# CITY OF PORTLAND

# BUILDING PERMIT

Job ID: 2011-02-497-DRG

has permission to Demo existing 21' x21' Barn- build new 24' x 28', slightly relocated, post & beam barn with storage loft provided that the person or persons, firm or corporation accepting this permit shall comply with all of the provisions of the Statues of Maine and of the Ordinances of the City of Portland regulating the construction, maintenance and use of the buildings and structures, and of the application on file in the department.

LOFT FLOOR FRAMING

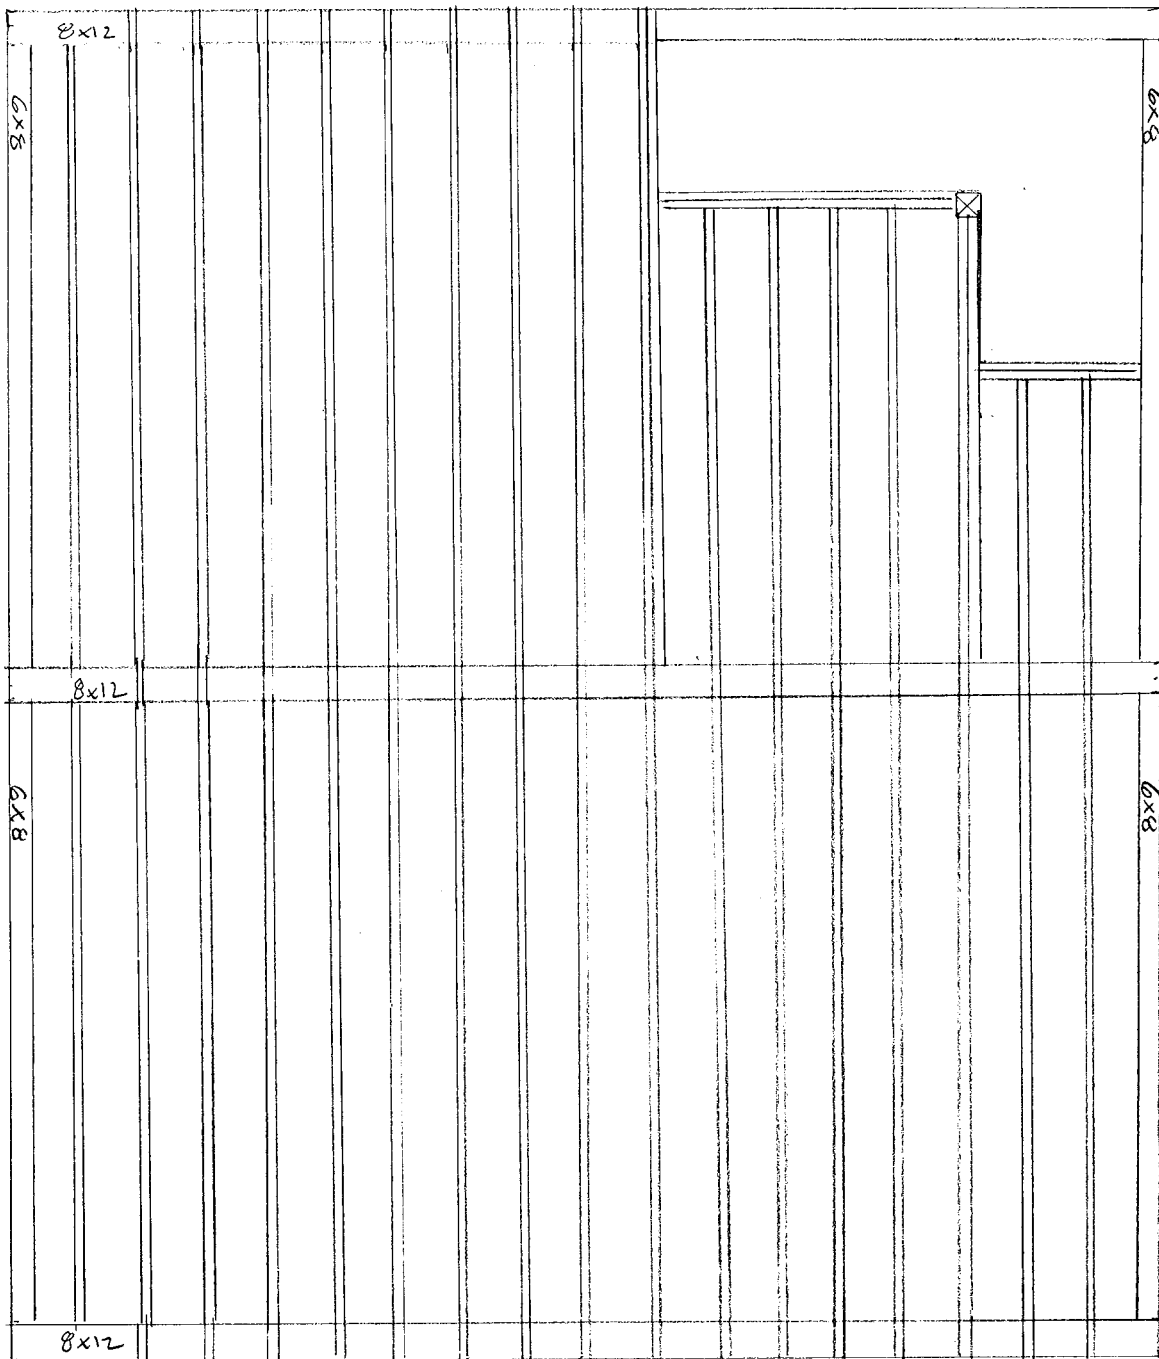
2. Permit approved based on the plans submitted and reviewed w/owner/contractor, with additional information as agreed on and as noted on plans, including tempered windows, foundation anchors at 4' O.C., lateral blocking of loft joists and full hanger dimension.
